Recommendation Report for Planning Permission for Works or Extension to a Dwelling

REF NO: WA/53/19/HH

LOCATION: Berberis
London Road
Fontwell
Walberton

PROPOSAL: To replace overhanging hedge with wooden fence and driveway gate.

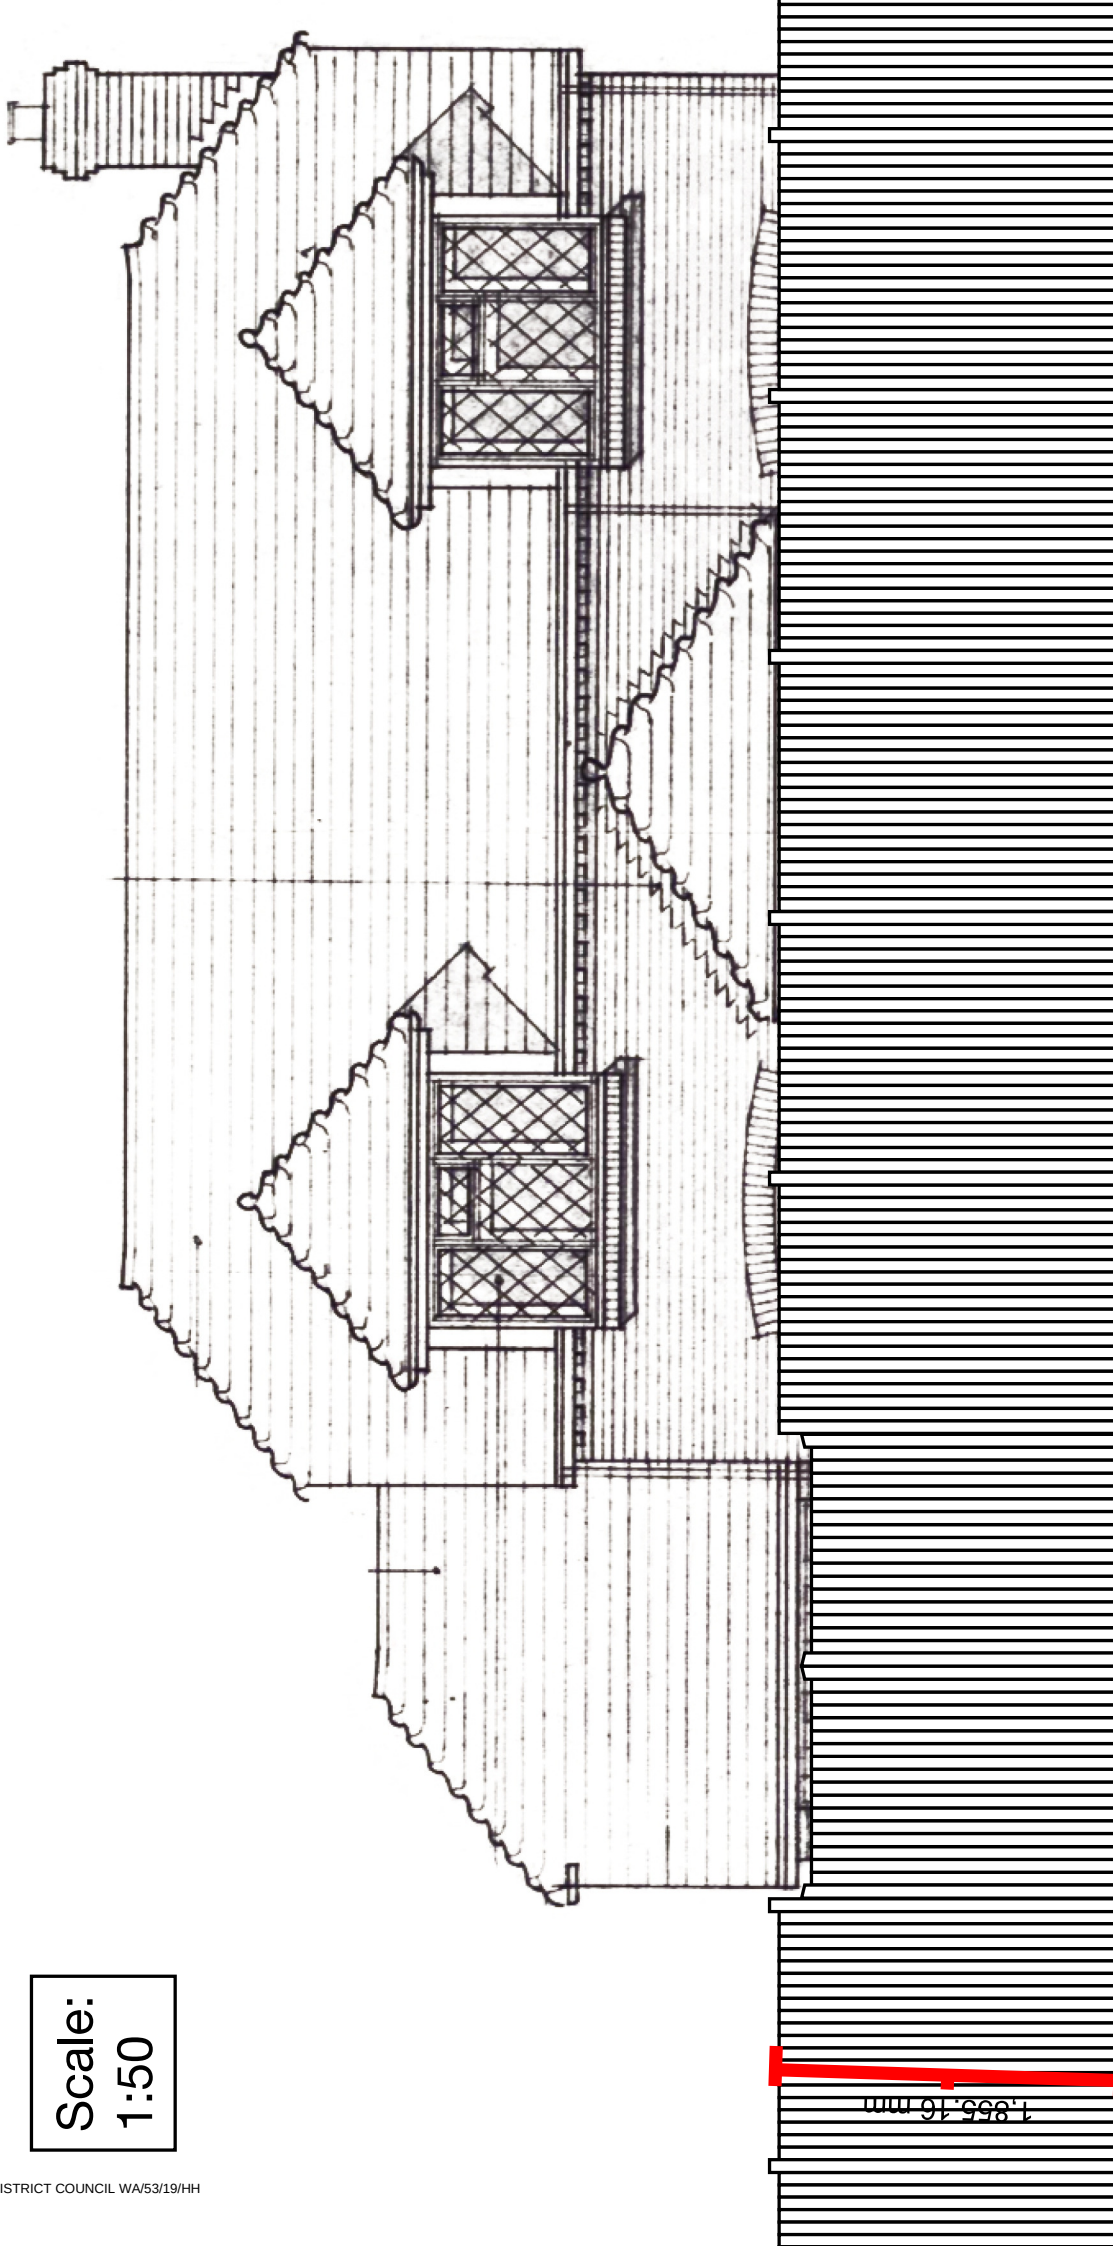
The proposed fence is constructed of wooden fence panels. The fence has a minimum height of 1.855m as shown in the plans. The fence spans 14.5m across the north western elevation of the property.

Within the locality there are a variety of boundary treatments present. There are examples of boundary treatment above 1m however they are all similar in appearance consisting of hedging which cannot be controlled, flint walling and some fencing. However, the height of the proposed is greater, the others are set back from the boundary line and are not one consistent barrier with no breaks. The proposal as a result of its design and scale appears unsympathetic and appears out of character with the surrounding area and existing front boundaries. As a result of this it appears as a prominent feature and as such is unduly dominant on the frontage of the property adjacent to the highway.

The Walberton Neighbourhood Plan outlines front boundaries should contribute to the overall street scene however this is not achieved as due to its size and appearance it is considered to stand out as an alien feature.

Due to the size and appearance of the fence it is considered to negatively impact upon the spatial pattern of the street scene and as a result would be harmful to the character and appearance of the wider area and is in conflict with DDM1 (1) of the Arun Local Plan.

- 1 The proposed Fence to the North Western boundary of the property by virtue of its height and design would appear as an unduly dominant feature and would have an unacceptable adverse impact on the character and appearance of the street scene and wider area in conflict with policy DDM1 of the Arun Local Plan and HP13 of the Walberton Neighbourhood Plan.
